Our Ref: ID 3060
Your Ref: SSD-45576956

2 June 2025

**State Significant Development Application for CMRI Gene Technologies Building
Westmead**

Peter Cinque
Senior Manager, Emergency Risk Management
NSW State Emergency Service

Figure 38 - PMF Flood Depths – Post-Development Conditions

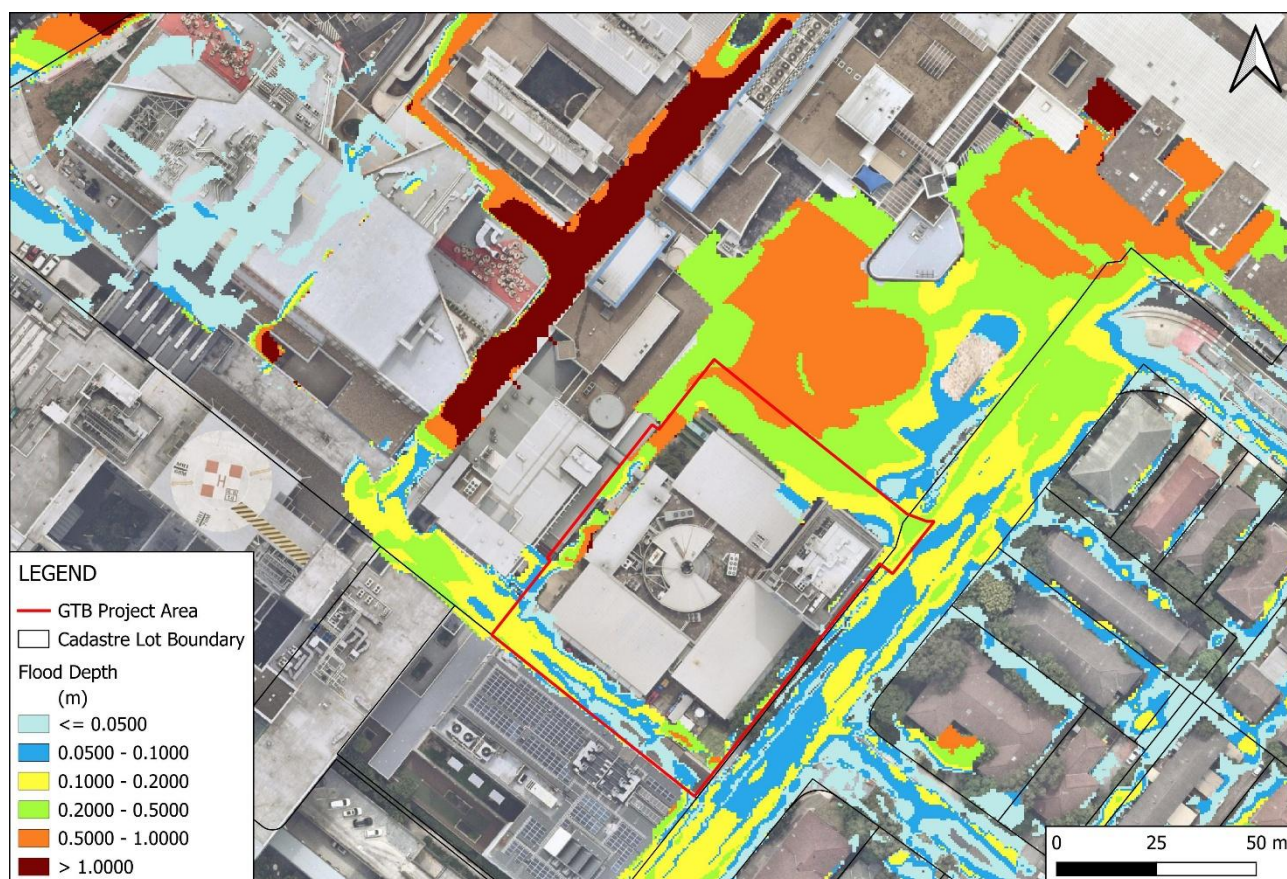
- **Note** the site is affected by flooding along the north-western and north-eastern boundaries of the site as frequently as the 20% Annual Exceedance Probability (AEP) event.¹ During the Probable Maximum Flood (PMF) the site becomes a High Flood Island, with *"the area near the north-western site boundary are as deep as 1.6m"*.²

Figure 41 - PMF Hazards – Post-Development Conditions

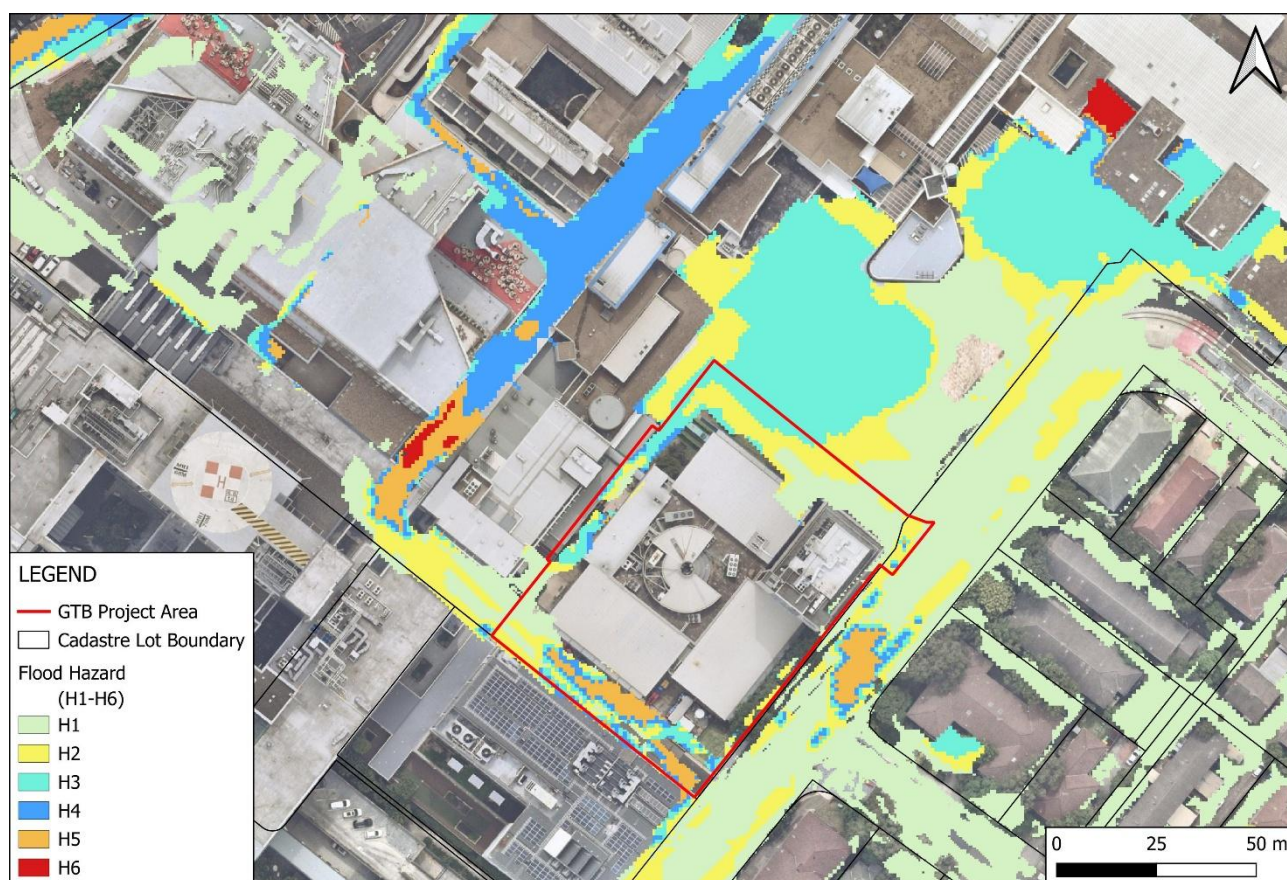
- **Recommend** seeking further information regarding the *"flood mitigation measures (have been) proposed (i.e. in the form of flood barriers or flood doors) on openings around the perimeter of the proposed building"*.³

We also request further information regarding the *“flood mitigation measures (have been) proposed (i.e. in the form of flood barriers or flood doors) on openings around the perimeter of the proposed building”*.¹² While the Flood Assessment Report refers to *“TTW’s civil design drawings attached within TTW’s SSDA Civil Engineering Report Revision B (Appendix B)”*¹³ these plans appear to contain only the proposed locations of these mitigation measures, with no information provided regarding the level of protection these are proposed to provide or their operation. Consideration should also be given to the impact on the development of failure of these features, particularly in the case of flood doors relying on human behaviour to ensure correct operation during flood events.
